From: Clare Dales
Sent: 23 January 2018 10:31
To: Simon Davis
Subject: RE: Forge House AL/129/17/PL

From: Simon Davis
Sent: 10 January 2018 17:55
To: Clare Dales
Subject: FW: Forge House AL/129/17/PL

Subject: Forge House

We have reviewed the further comments from the Design Officer and offer the attached draft plan. Do these plans overcome the concerns regarding the roof line? If so we will provide substitute plans for formal consideration.

scale	date
1:100 @ A3	October 2017
job no	drawing no
16078	02.03
	rev
	B

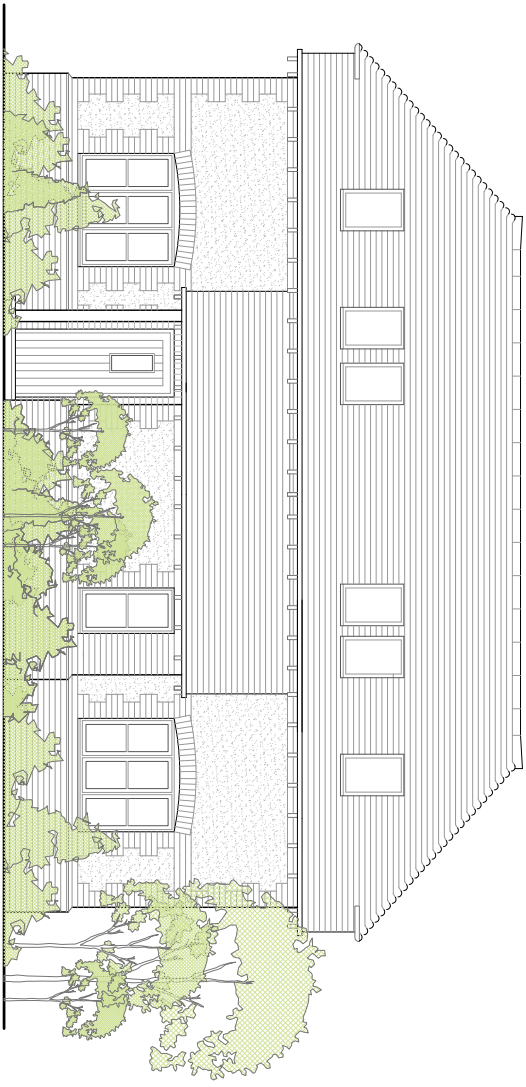
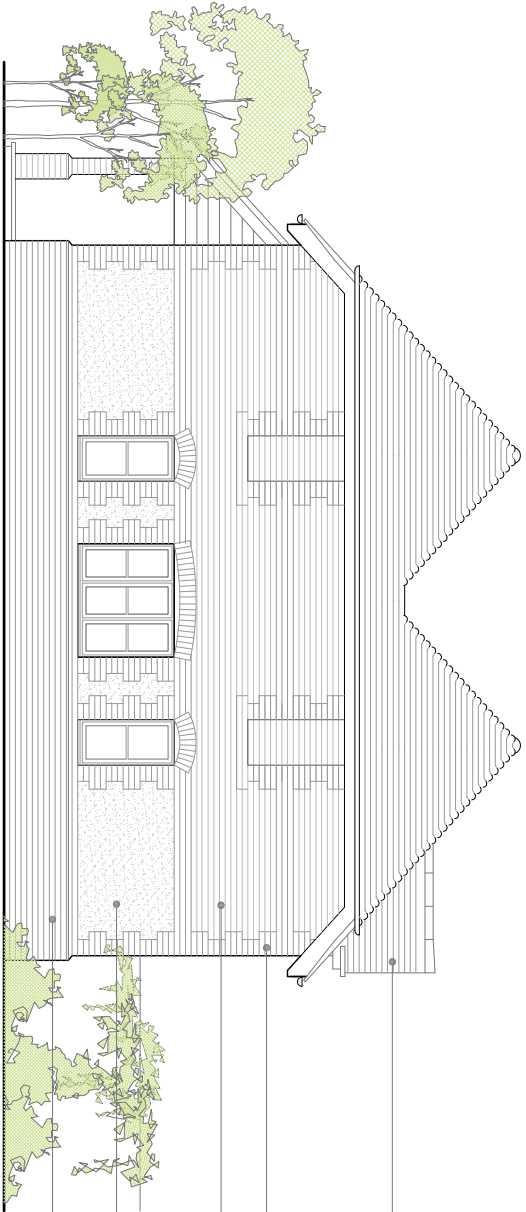
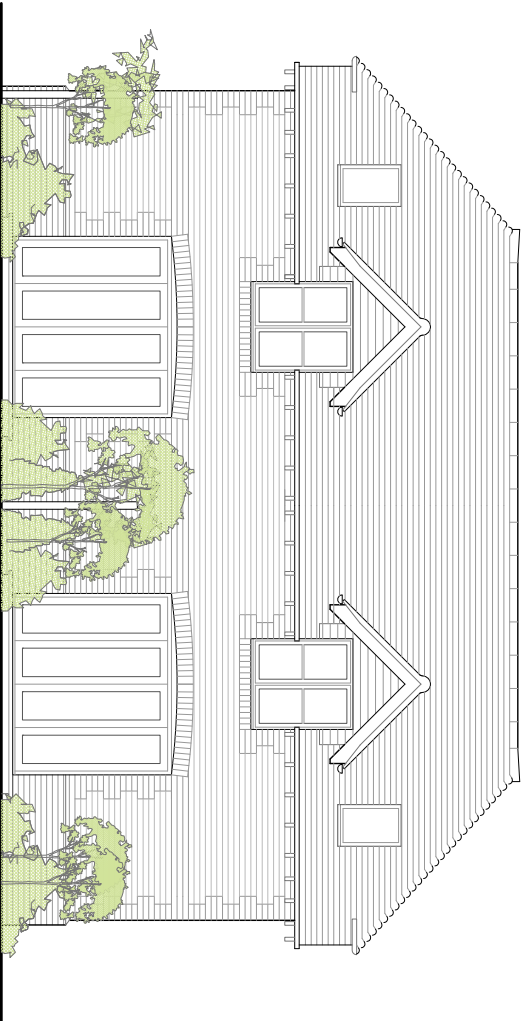
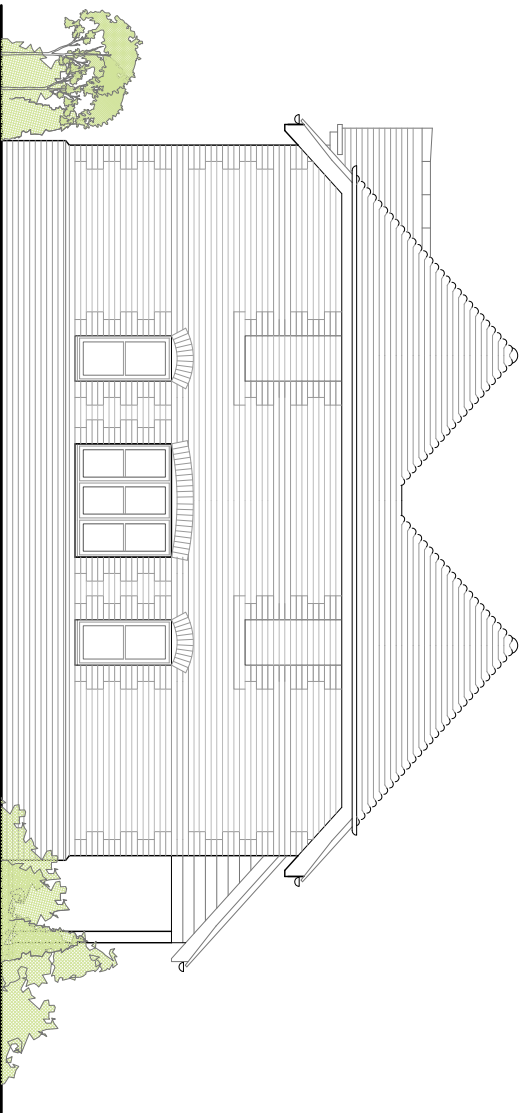
The alterations as below are minimal, and make no substantial difference to my previous comment, which relate to the building and also the walling/setting issues.

I have received a new plan containing 3 alternative options for the north elevation treatment. However, 1 of the option is the same as originally submitted and the other two essentially just reinstate dormers with different window design at the expense of the velux. Can you comment. Note that it looks like if we still object, they may withdraw.
